**From:** Amanda Scholes on behalf of Planning.Responses  
**Sent:** 07 February 2018 08:37  
**To:** Planning Scanning  
**Subject:** FW: [EXTERNAL] - BE/96/17/DOC - Site 6, Chichester Road

I write in relation to the above application for the discharge of conditions 4 and 6 of planning approval BE/122/10/. I have recently taken over this application following the departure of David Innes from the Council.

Berkeley Homes (Southern) Ltd - North Bersted - Phase 2 LEAP

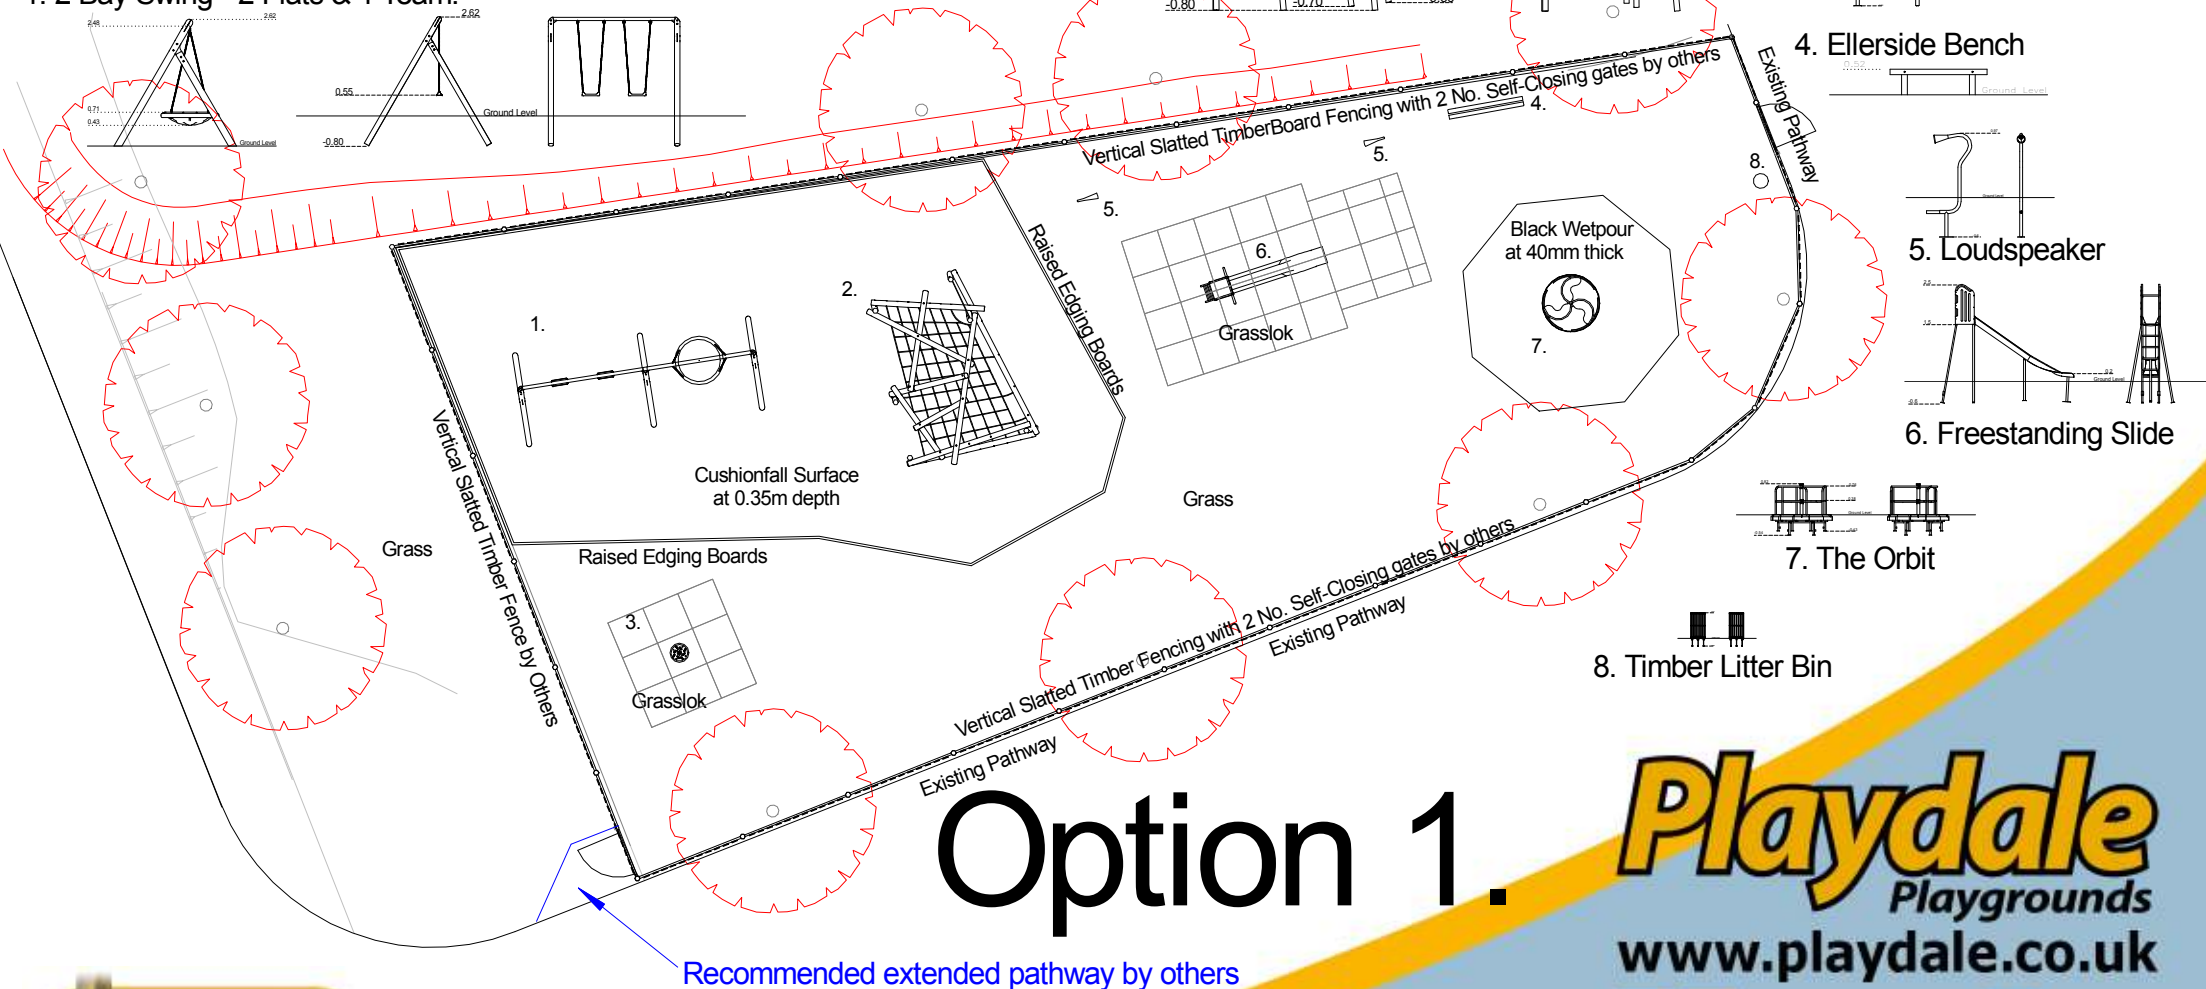
Our technical team have liaised closely with ADC Open Space Officer (Anthony Baker) to agree the fencing type. The option was put to ADC to have metal bow top fencing but was declined by Anthony, who has requested the fencing be consistent across the development. As the land is to be adopted by ADC, please advise if this position has changed. I have discussed this with Anthony further and can confirm that ADC would prefer to have bow top fencing for this play area rather than vertical slatted timber fencing, and confirm that bow top would be agreeable to be adopted by ADC.

The gate to the rear of the play area annotated as opening outward on the current layout; has been changed to an inward opening gate. An outward opening gate would have prevented ADC adopting the play area. It has been agreed that the entrance gate will remain as opening outward for vehicular access for maintenance. The gate has been increased in size to accommodate maintenance vehicles and a path has been introduced to move the gate off the road. We accept this offer of an outward opening gate as acceptable for vehicular access for maintenance.

- The fencing type should be changed to metal bow top at appropriate height, rather than vertical slatted timber fencing as shown.
- The gate should be connected to pathways for ease of access by users and wheeled users and any gate bordering a road should open inwards.

I have consulted with Anthony Baker further on this and comment and confirm below in red.
